Office of Environment & Heritage

Date: 1st February 2012
Your reference: SSI 5039
Our reference: DOC13/3081
Contact: Liz Mazzer
68835325

RE: Chaffey Dam Augmentation Project (MP SSI 5039) – Exhibition of Environmental Assessment

I refer to your letter dated 11th December 2012 seeking comment from the Office of Environment and Heritage (OEH) on the Environmental Assessment (EA) for the Chaffey Dam Augmentation Project.

**Figure 9.1** Potential impacts at sites: impacted sites (red), sites to be fenced during road upgrades (yellow), sites that will not be impacted (green) (Provided by State Water)

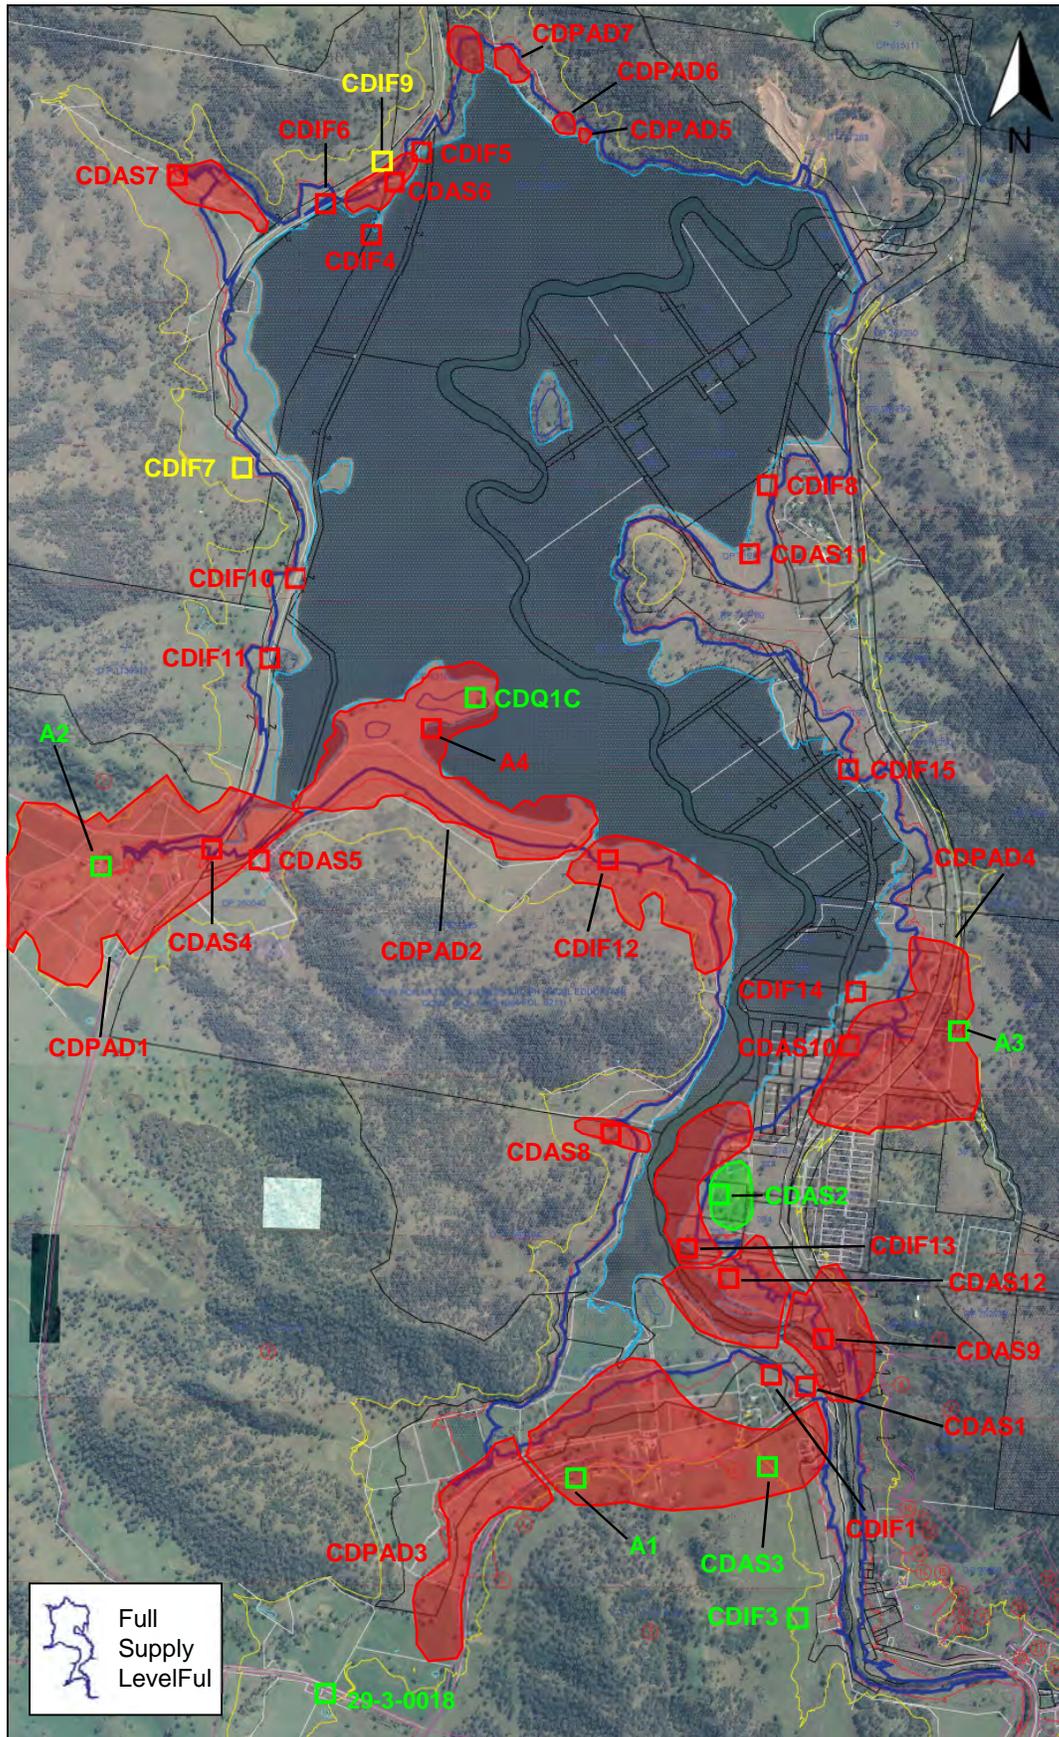
Sites which fall on the border of the proposed inundation level (CDIF7 and CDIF9) should be fenced off during any construction works associated with the Tamworth-Nundle and Western Foreshore Roads and associated bridge realignments to avoid indirect impacts during construction.

OEH considers that these sites will also require buffer zones to ensure their protection.

That appropriate buffer zones be applied around the sites to ensure their protection.
